Your Ref: OWPC2608
Our Ref: A/46/14/HH 31-03-2014
Please ask for:
Mr P Cleveland

Retention of infill Brickwork to front boundary wall. This application affects the character and appearance of Angmering Conservation Area

Woodford Villas 2 High Street Angmering

DRAWING TITLE
NEW FRONT BOUNDARY WALL
ELEVATIONS, PLAN AND SECTION

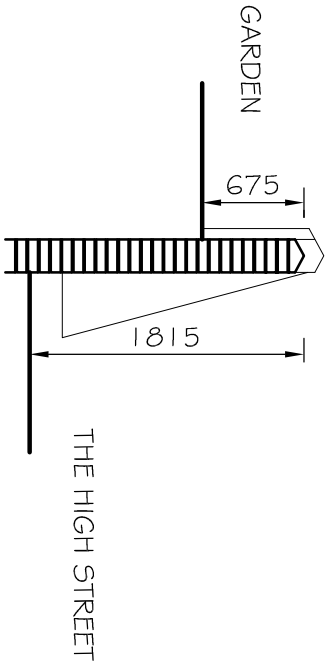
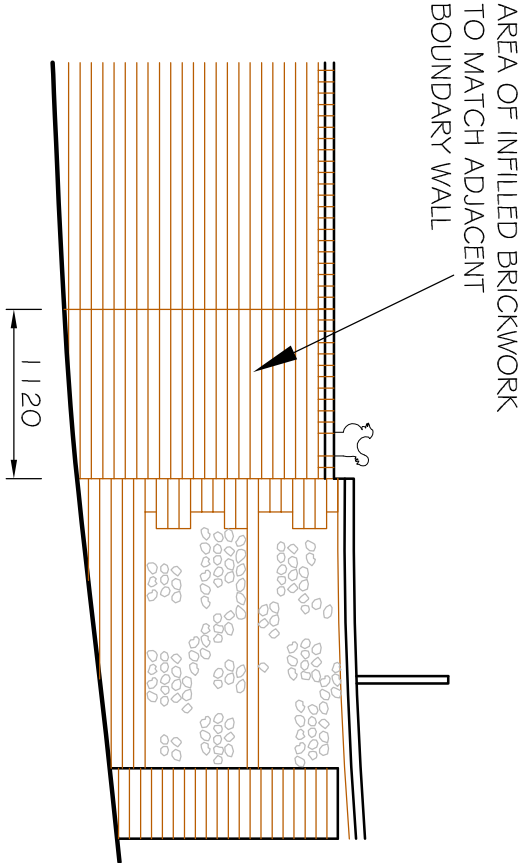
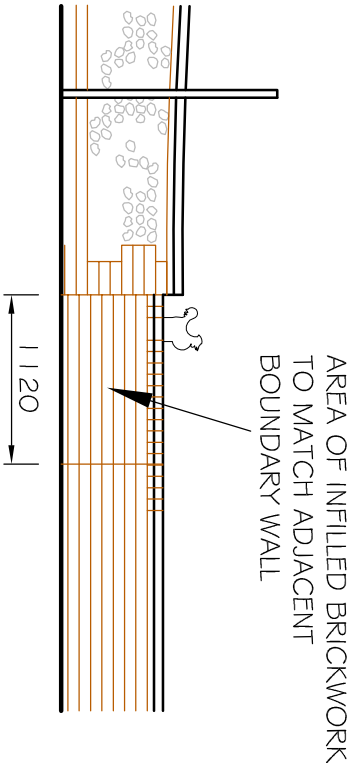
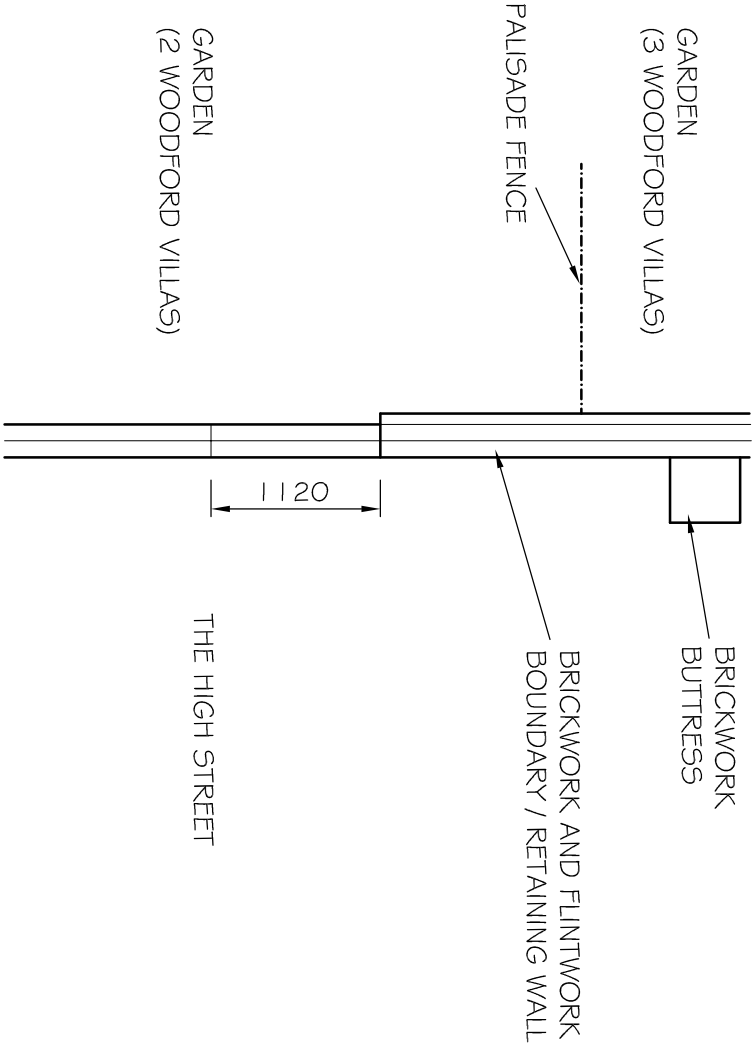
*The wall does not fit in with the conservation area.
It reduces access to other properties. Makes visitors feel uncomfortable walking past other houses to get to ours. Makes it harder for any emergency services to gain access.*
